Application: SSI 7485

I write regarding the proposed modification to M4-M5 Link, Mod 2 The Crescent overpass and changes to pedestrian infrastructure in North Annandale, Rozelle and Rozelle Bay Foreshore area.

Figure 4-2 Pedestrian and cyclist bridge infrastructure options

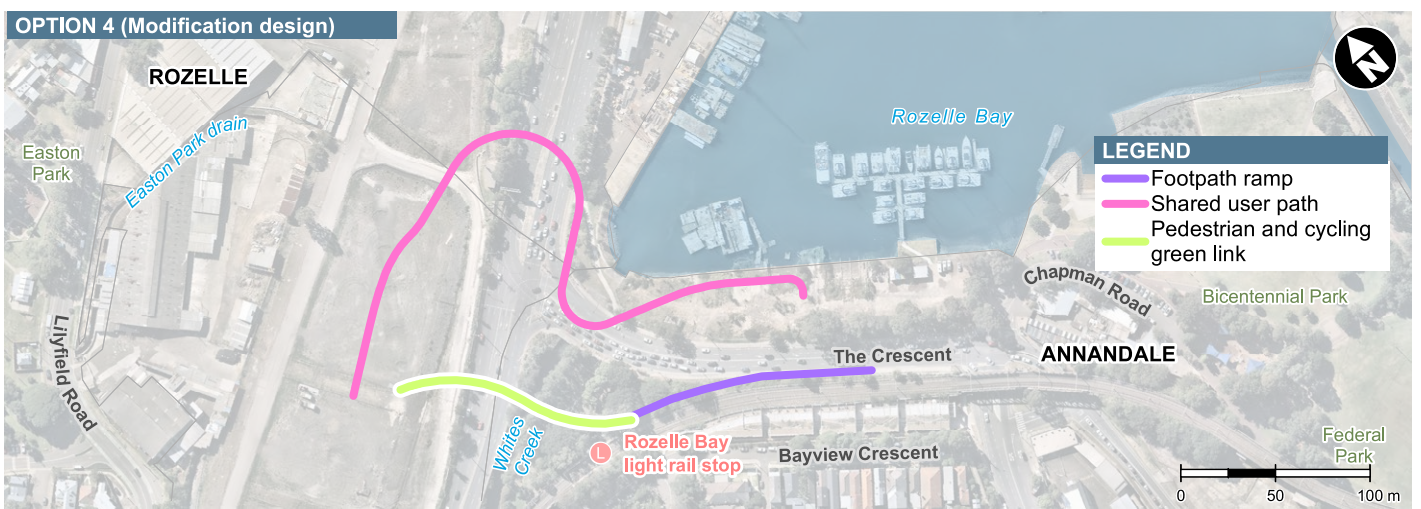
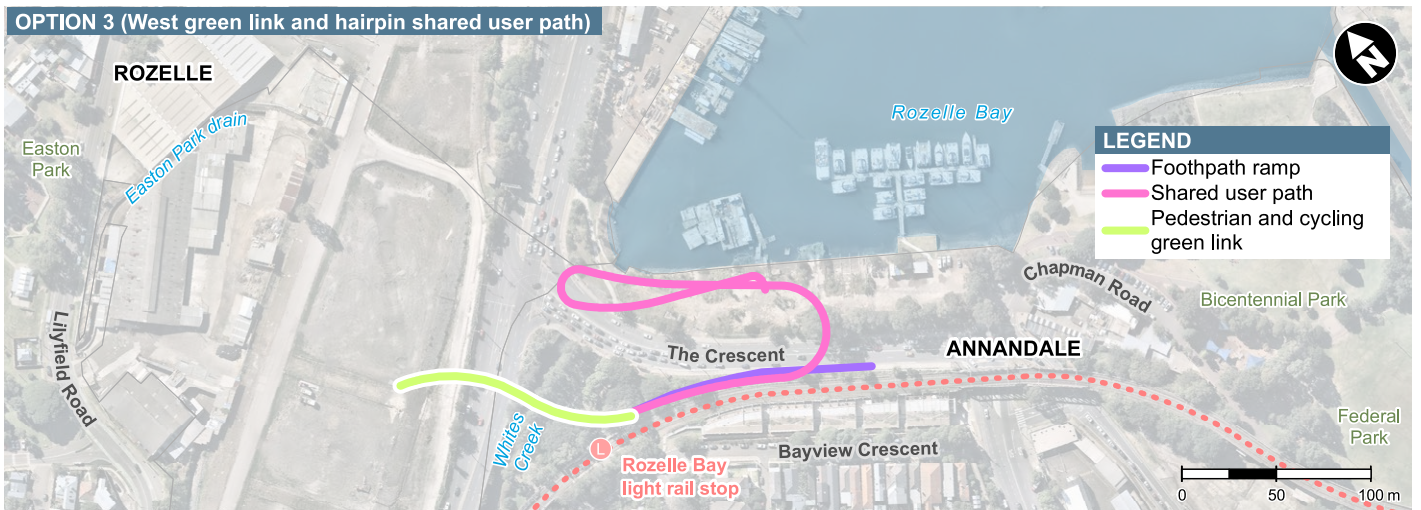
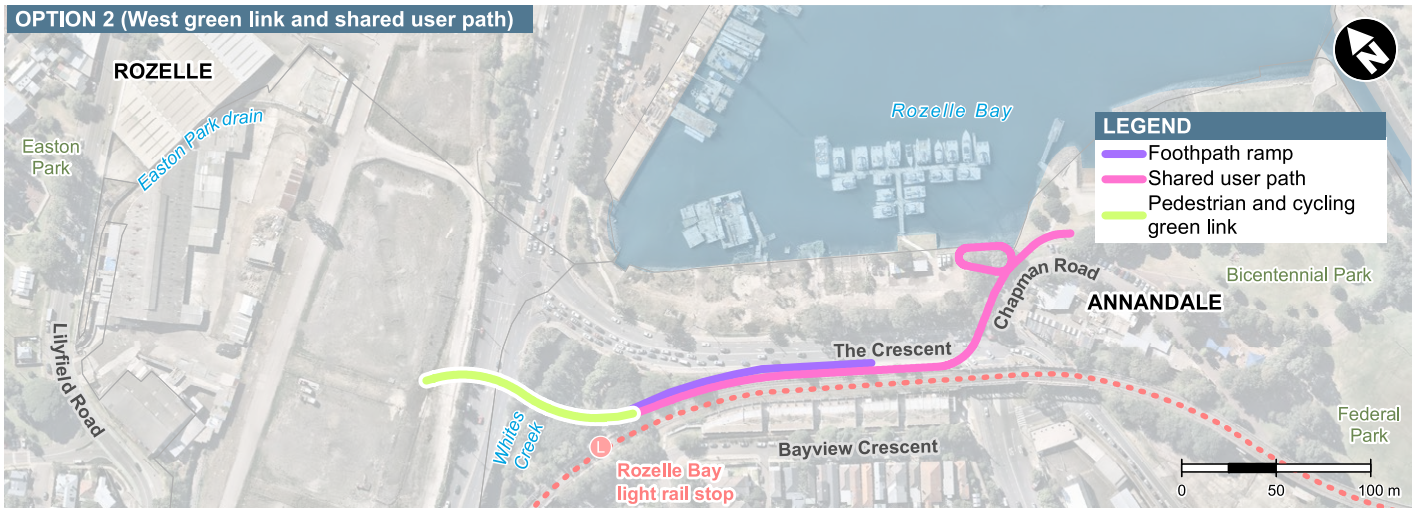
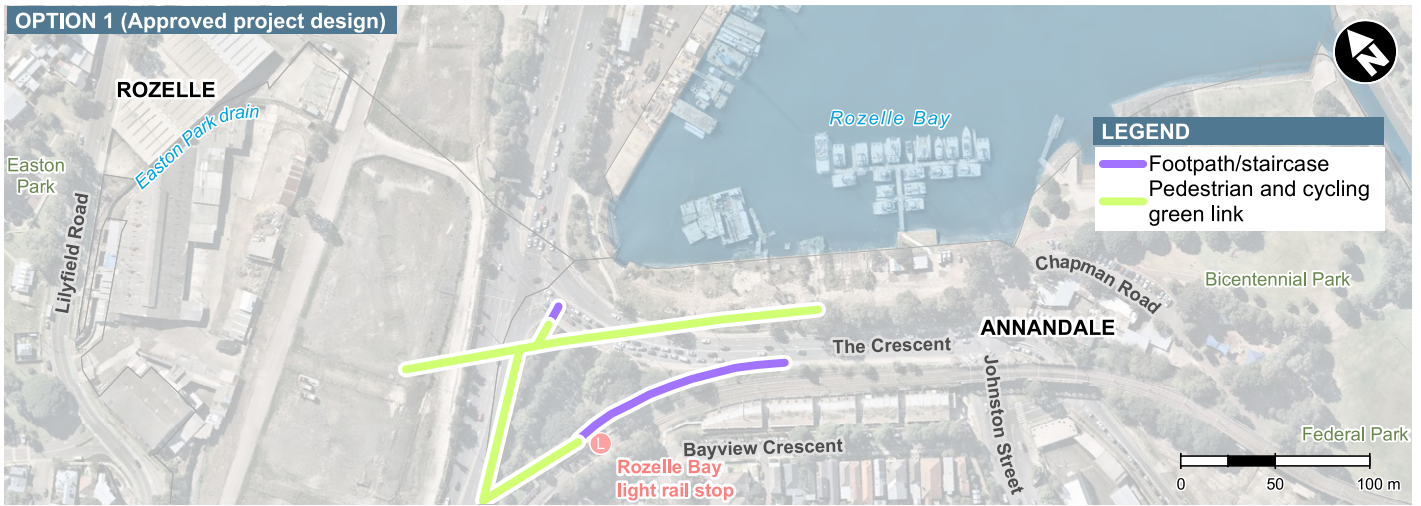
- The significantly reduced safety and increased risk for pedestrians and cyclists with removed access over The Crescent to Bicentennial Park and the increased traffic along Johnson Street.
- Being required to cross five sets of pedestrian lights at The Crescent as my option to reach the foreshore from Annandale or from Rozelle Bay light rail stop.
- Removal of direct active links to the foreshore, cutting the community off from the area and the proposed revitalisation of the entire Bays Precinct, including linking the Light Rail and Bus stops to a Ferry wharf and Metro station.
- Urban and landscape design that is being built before a finalised Masterplan for the area.
- Traffic changes that limit movements around the suburb and create further congestion in the local streets of Annandale, Forest Lodge, Glebe, Lilyfield and Rozelle with no planning to deal with these.

Figure 4-4 Elevation: Indicative view of The Crescent overpass

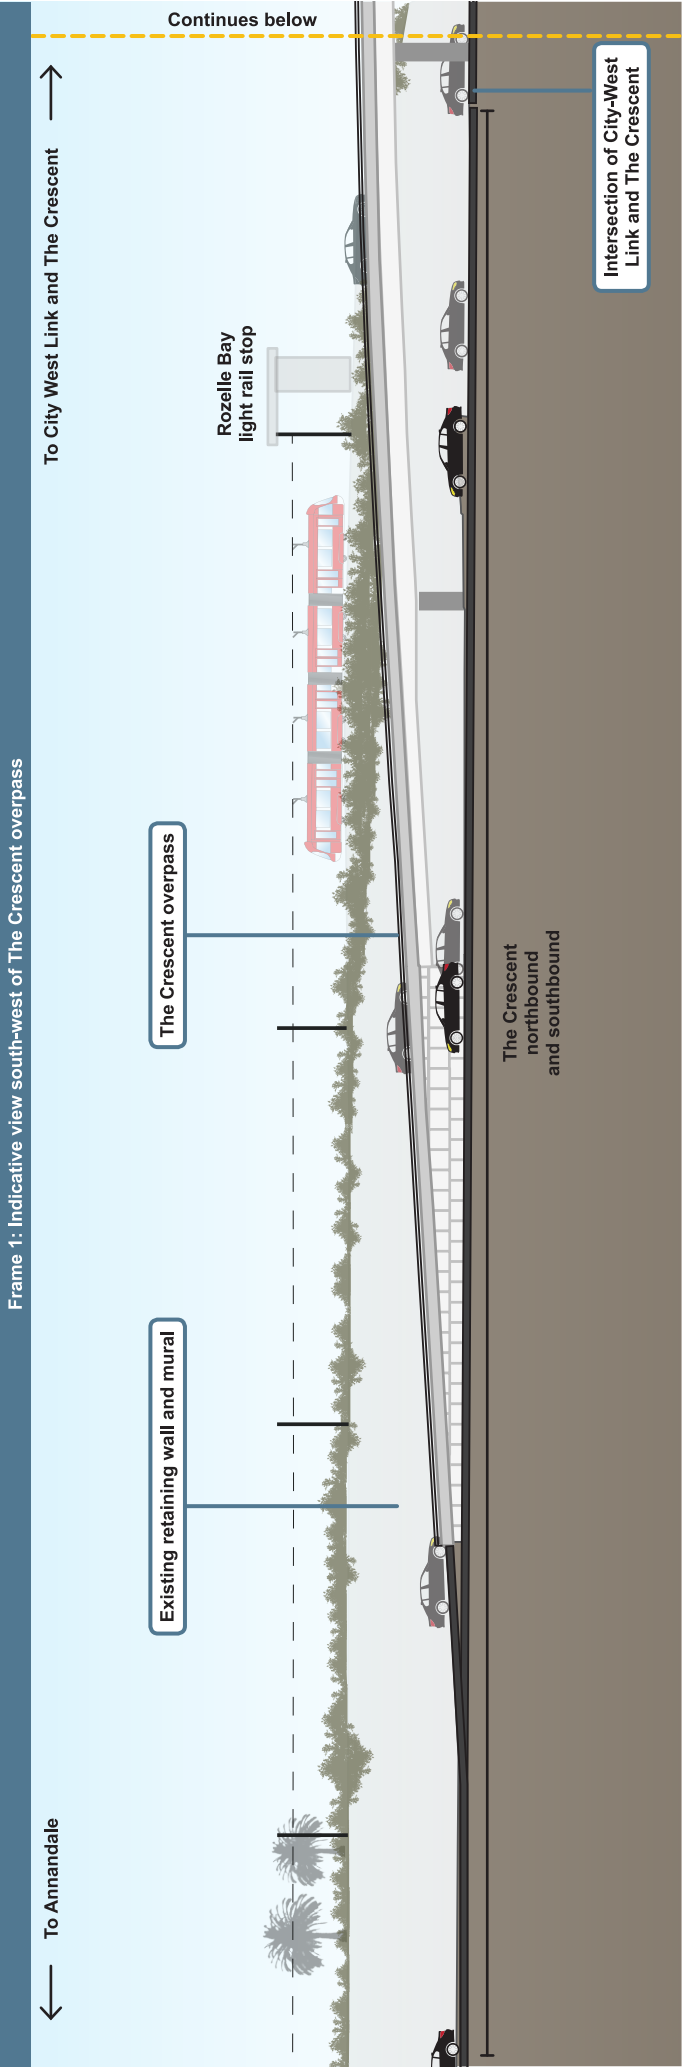
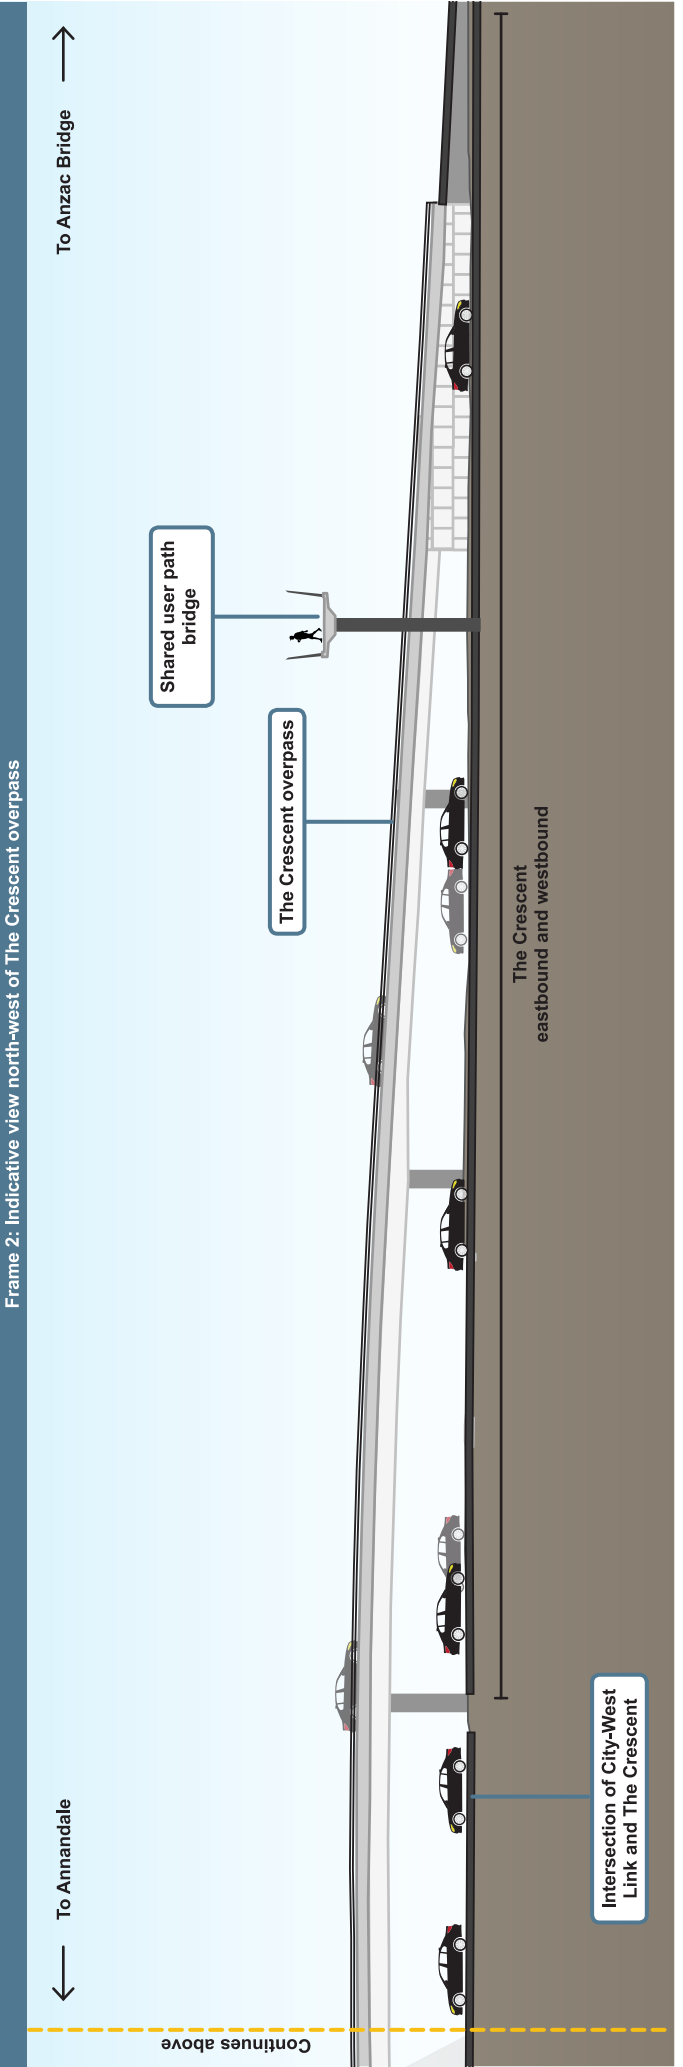
I request RMS work with the community to explore alternate design options to the proposed new car overpass design and the changed pedestrian and cyclist links. I am seeking the reinstatement of the safe, direct access from the approved EIS GreenLink to create a continuous green open space connection from the Rozelle Rail yards and Annandale to the foreshore. The GreenLink was more than just a walk way - it put people central to the design, maximising safety, and providing much needed accessible open space for the community now and into the future Bays Precinct design.

Figure 4-6 Elevation: Indicative view of Rozelle Rail Yards Pedestrian and Cycling Green Link

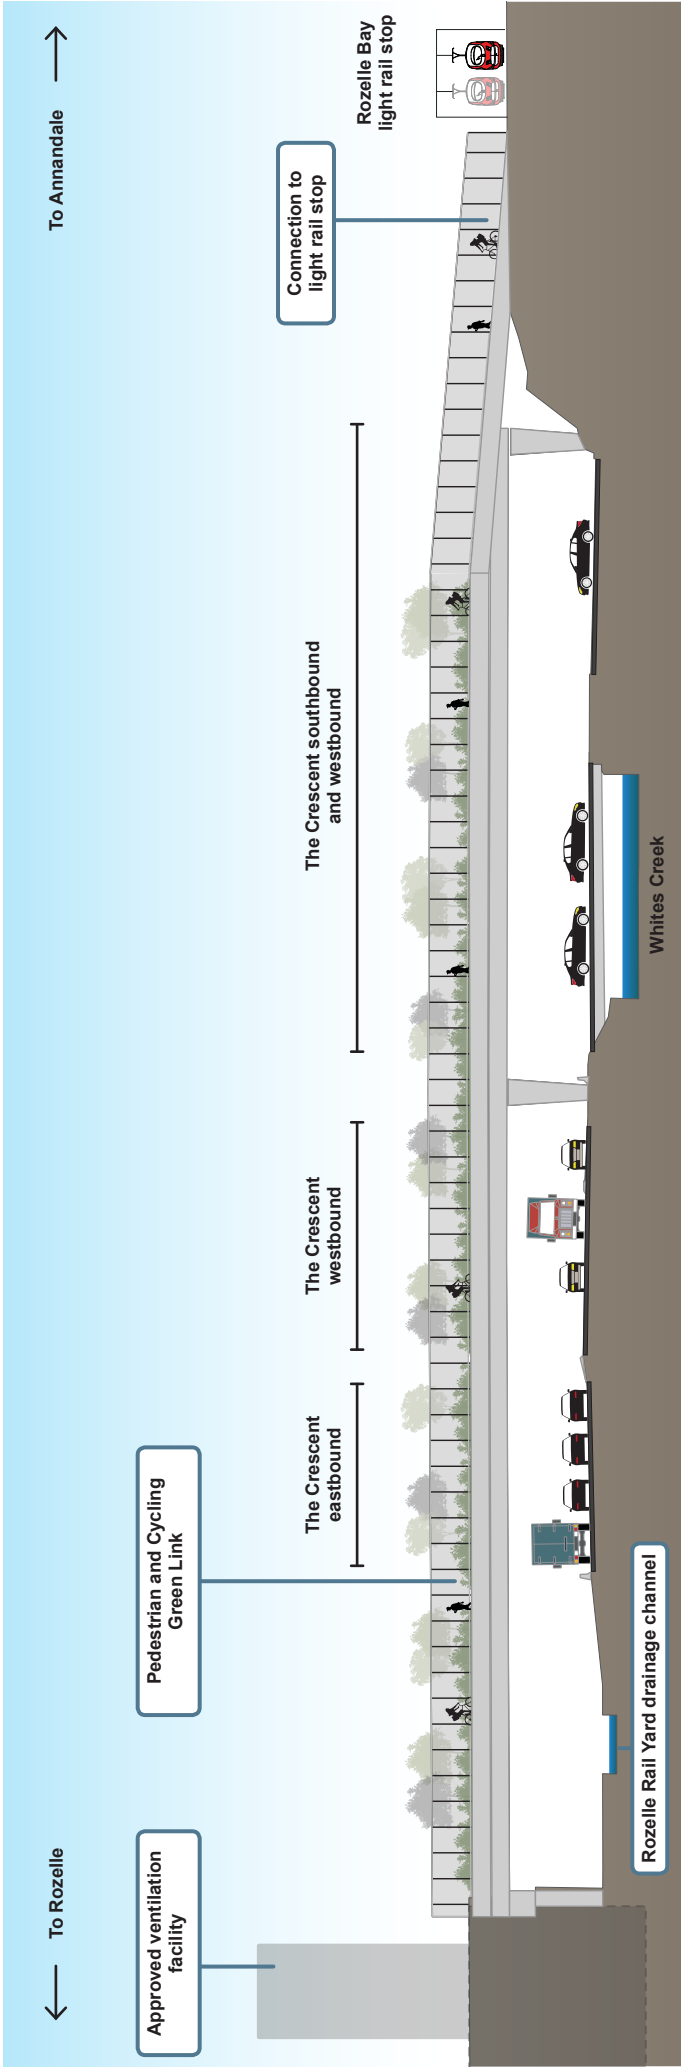
- Reinstate the GreenLink connecting communities and green open space from Rozelle to Bicentennial Park
- Relocate and design pedestrian and cyclist connections that are continuous, safe and direct.
- Design the modification infrastructure and active links in response to the character of the suburbs, the location of the foreshore and it's potential future development.
- Provide pedestrian and cyclist paths that maximise people safety and do not force them onto busier streets, unsafe concrete plazas and caged walkways.
- Integrate active and direct connections to all active transport - including the future Metro West and Foreshore Ferry Wharf
